Online Comment

Application	H11-0056-26
Location	4 High Street Long Sutton Spalding PE12 9DB
Proposal	Change of use from former gift & interiors shop to ground floor and hair & beauty salon on first floor to solicitors office to include alterations and insertion of rooflights

Name	Greg Watkinson
Address	Conservation Officer

Date Submitted	19-02-26
For/Against	Comments

FRONT NORTH ELEVATION

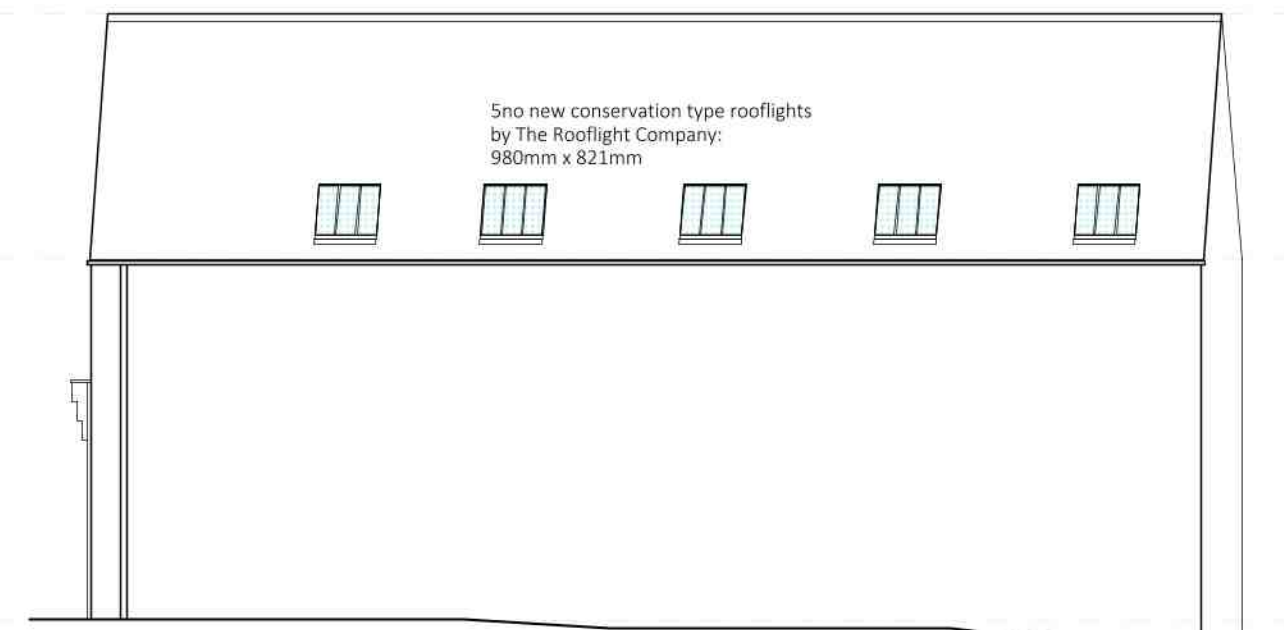
I am satisfied with the basic principle of the proposal, and have no concerns with any aspect of the proposed scheme other than the proposed infilling of the inset coach door to the east side of the principal elevation. It should be noted that the proposal site is in a central location within the Long Sutton Conservation Area. Moreover, the property is considered to be a non-designated heritage asset (NDHA) because it is recorded as a 'building of local heritage' by the LPA. Because of this status, and the influence the property has upon the wider appreciation of the Conservation Area, it is important to ensure that any proposal is as sensitive as is practically possible.

I would therefore recommend that with reference to the proposed infill of the doors, detail should be provided showing that, in order to better replicate the appearance of the window situated immediately to its east, a matching chamfered brick cill will be used. Moreover, to ensure that the readability of the existing opening is retained, the brickwork and window should be inset and not flush with the existing wall. Should the application be approved, then I would recommend that a condition be applied requiring the detail of the proposed new window be submitted, and another requiring the frames to be painted black to match the existing fenestration on site. Lastly, conditions should be applied ensuring that the brickwork matches the existing in terms of brick size and bond, and that the final brickwork on the frontage elevation be painted to match the existing finish on the facade, and to avoid any new brickwork appearing out of keeping with the remainder of the property.

As a note, I would also recommend that for the avoidance of doubt, drawing no. 25037/PL04 should be amended to remove any references to 'timber panels' when the HIA seems to suggest that those panels would be windows. This vague wording could suggest a fully timber panel without glazing, in contrast with the HIA. Suffice it to say, a solid timber panel situated on the front elevation would not be seen as acceptable.
